Address: 21 Mayfield St.

CHECK-LIST AGAINST ZONING ORDINANCE

Proposed Use/Work - build 2 1/2 story duplex (2 townhouses) 44' x 22'

ELEVATIONS

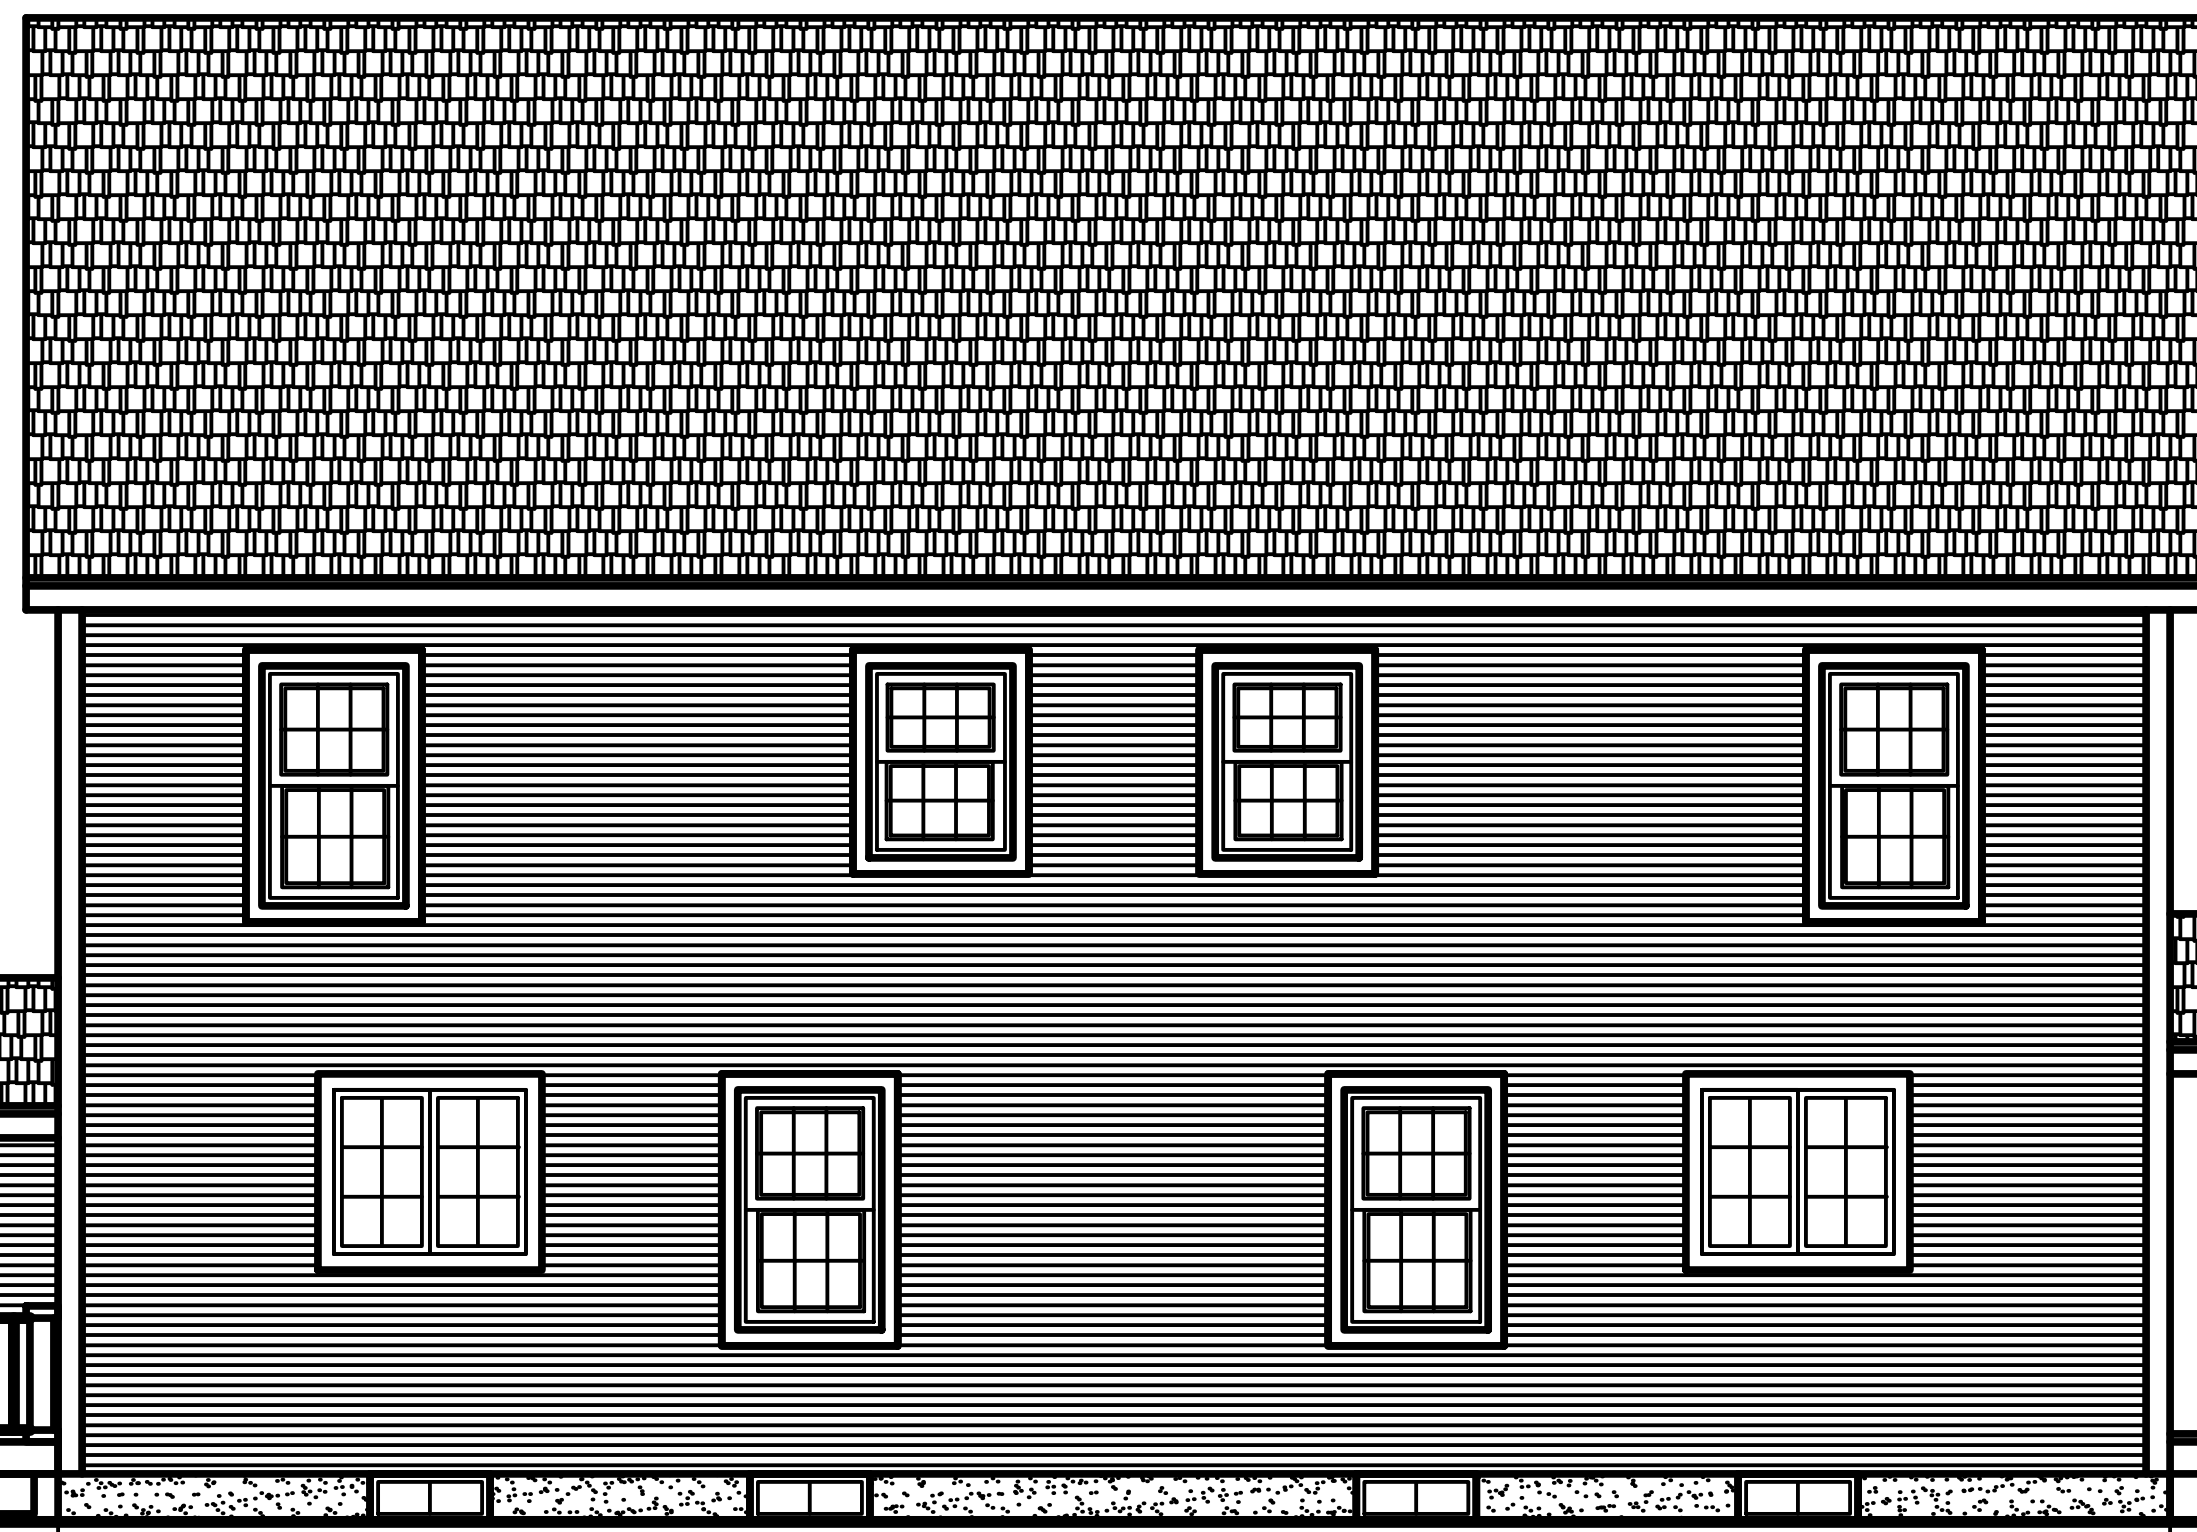
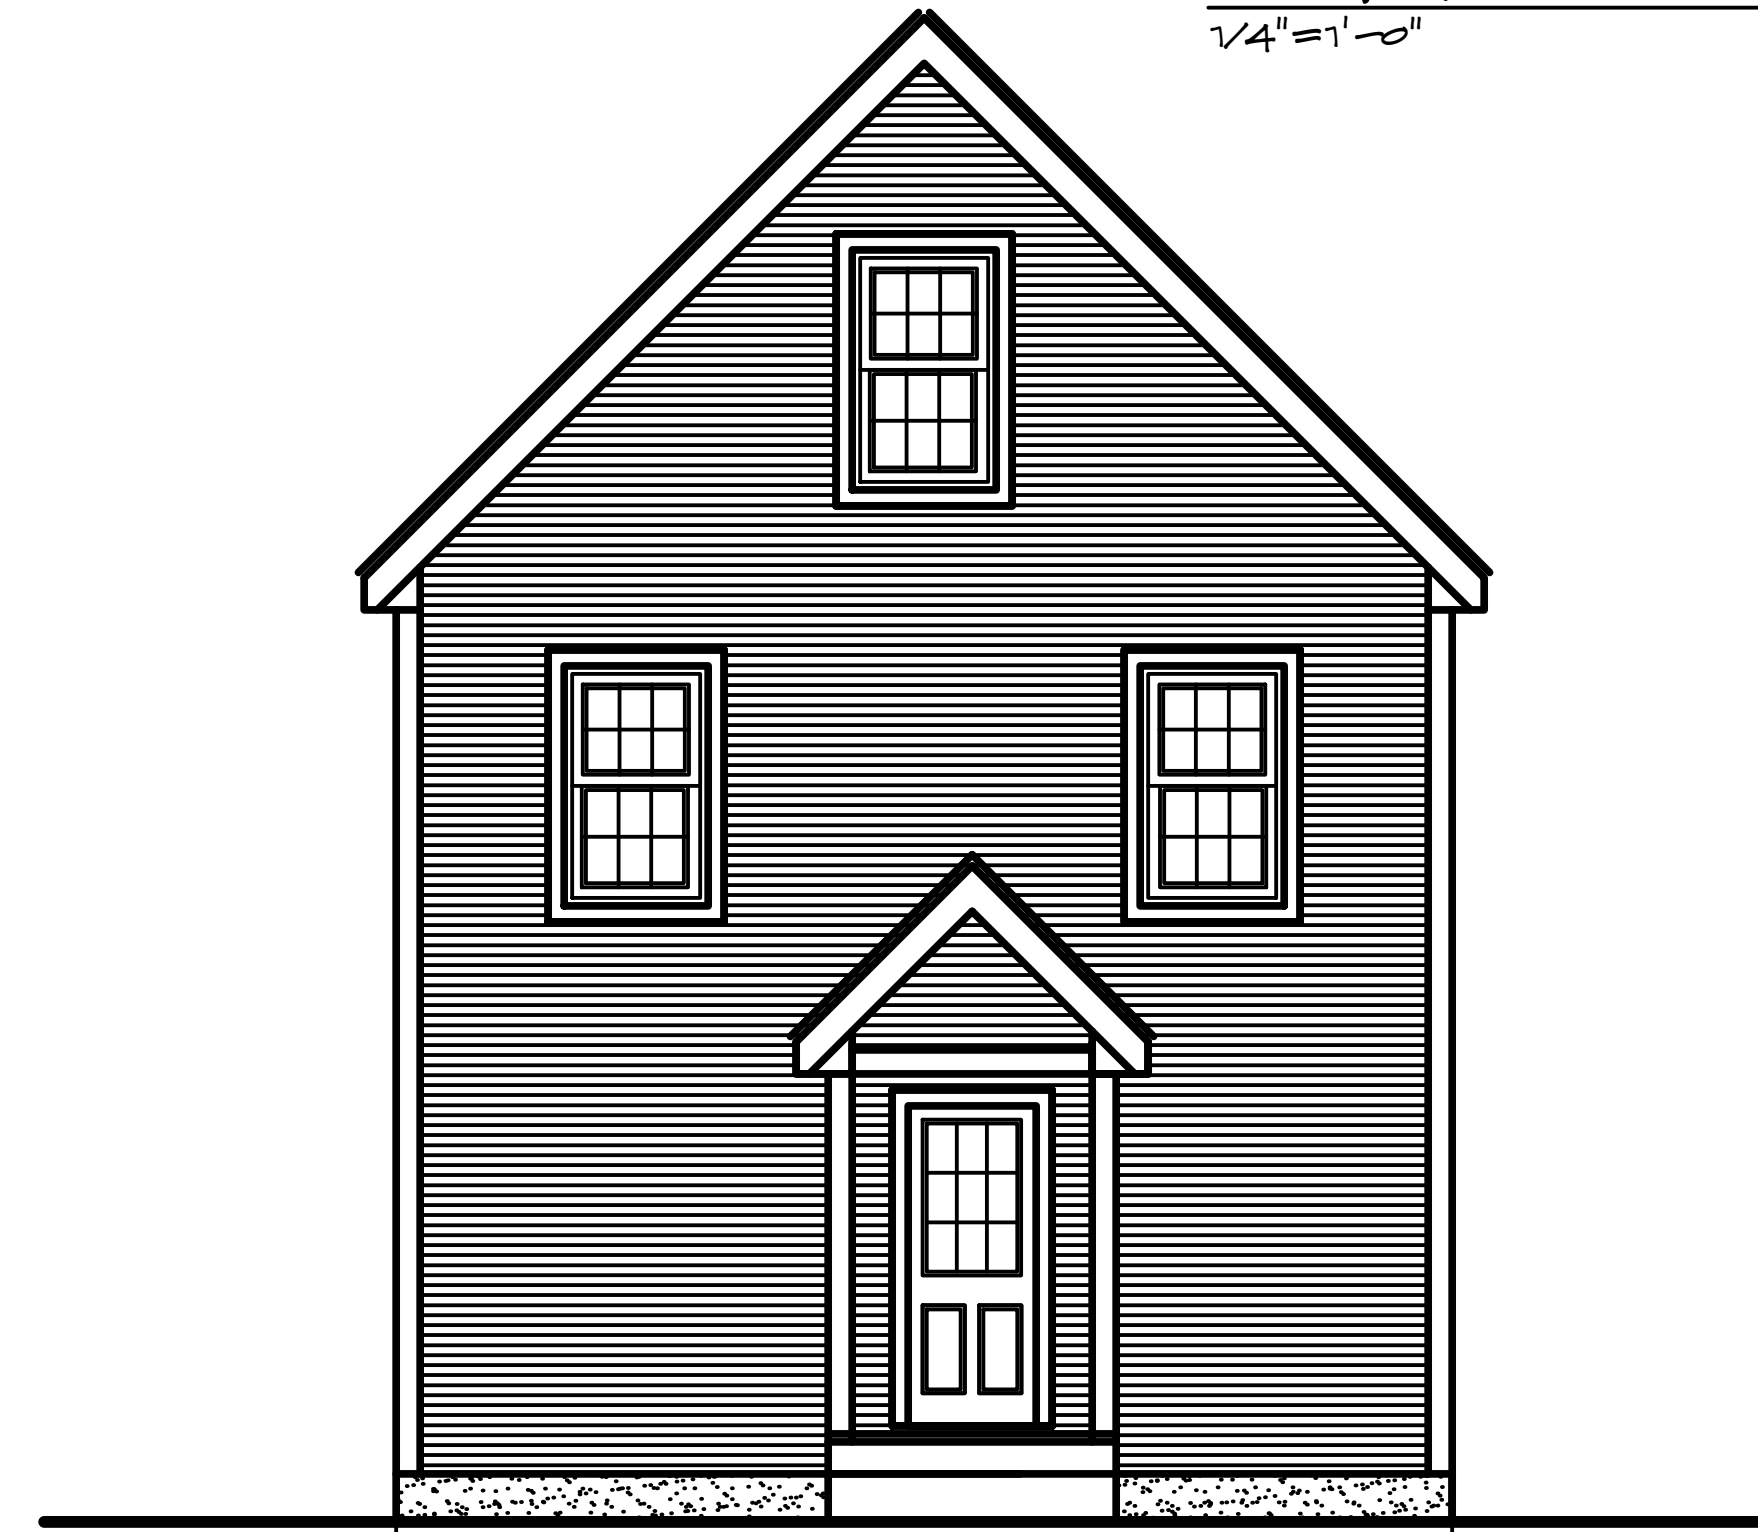
Height - 35' max. - 31.27 scaled to ridge. OK
